OUT15/19006

Energy From Waste Proposal, Eastern Creek (SSD_6236) Response to exhibition of Environmental Impact Statement

Eastern Creek Energy From Waste Proposal (SSD_6236) Response to exhibition of EIS Additional Comments by DPI Water

**Figure 1. Ropes Creek Tributary illustrating existing and amended proposal features**

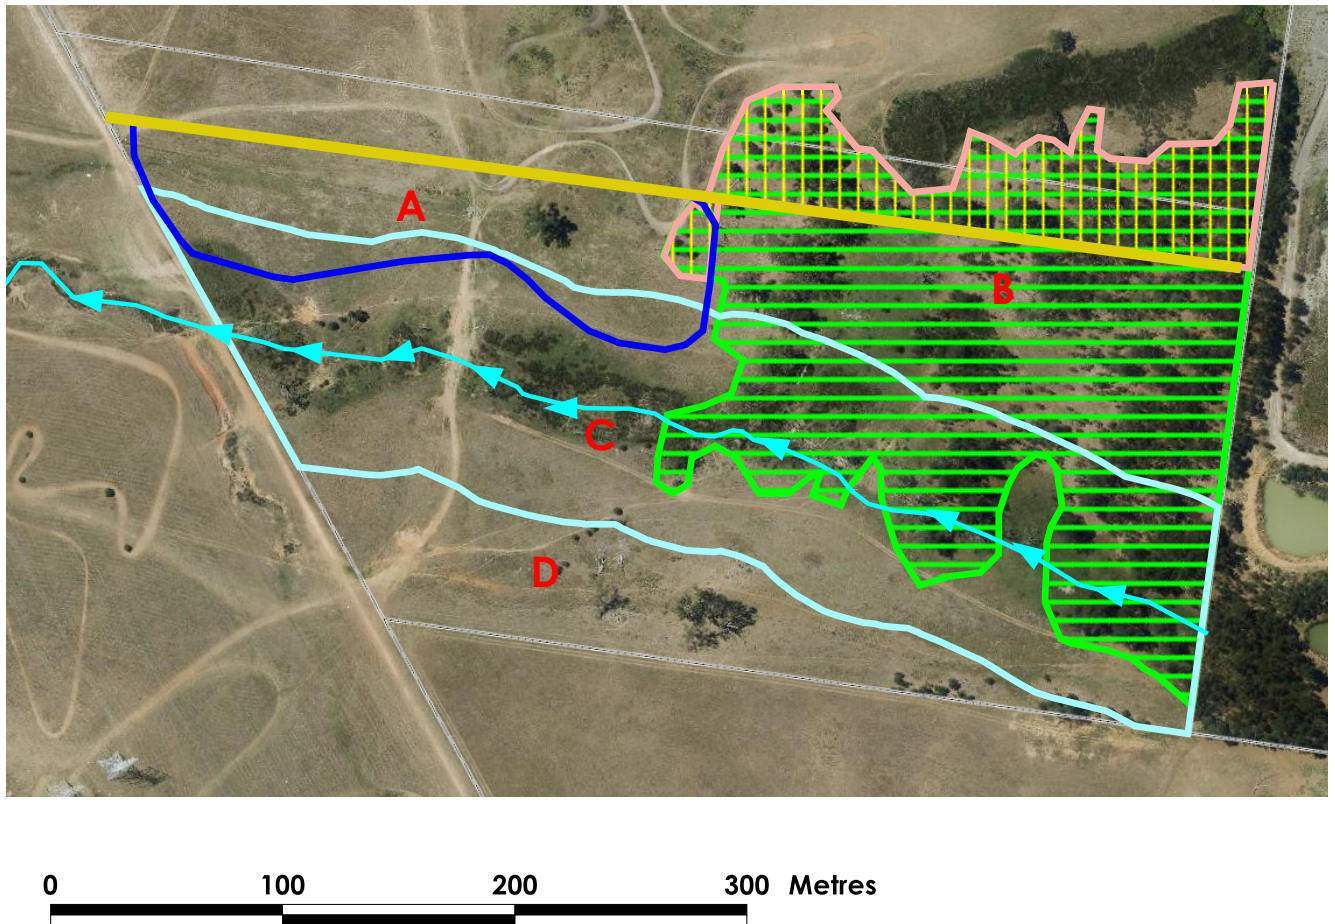
Clarification is required on the riparian corridor width required to be established along either side of the Ropes Creek Tributary at the site and whether the riparian corridor width is meant to be consistent with *SEPP 59 – Eastern Creek Precinct Plan (Stage 3)*. The project as presented in the EIS is not consistent with the riparian corridor width outlined in the precinct plan. The project layout may need to be amended depending on the minimum width that is required to be established along the creek.

The EIS notes an assessment of the proposed works against the provisions of the Eastern Creek precinct plan has been undertaken (Section 8.6, page 93) but a 20m wide riparian setback is not consistent with the Eastern Creek precinct plan. The precinct plan requires a 40m wide riparian corridor plus a 10m wide buffer zone to be established along either side of the Ropes Creek Tributary. Clarification is required on the riparian corridor width that is required to be established along either side of the Ropes Creek Tributary.

If the SSD is approved, it is recommended a condition of approval is included which specifies the riparian corridor width required to be established along either side of the Ropes Creek Tributary at the site. The project layout may need to be amended depending on the minimum width that is required to be established along the creek.

1. A riparian zone shall be established and maintained along Ropes Creek Tributary on the site, for its entirety within the site. The extent of the riparian zone is to be measured horizontally landward from top of bank either side of the watercourses and the width is to be consistent with *SEPP 59 – Eastern Creek Precinct Plan (Stage 3)*.
[Note this condition needs to specify the minimum riparian corridor width that is required to be established along either side the Ropes Creek Tributary at the site. The condition needs to clarify if the riparian corridor width is meant to be consistent with SEPP 59 – Eastern Creek Precinct Plan (Stage 3)]
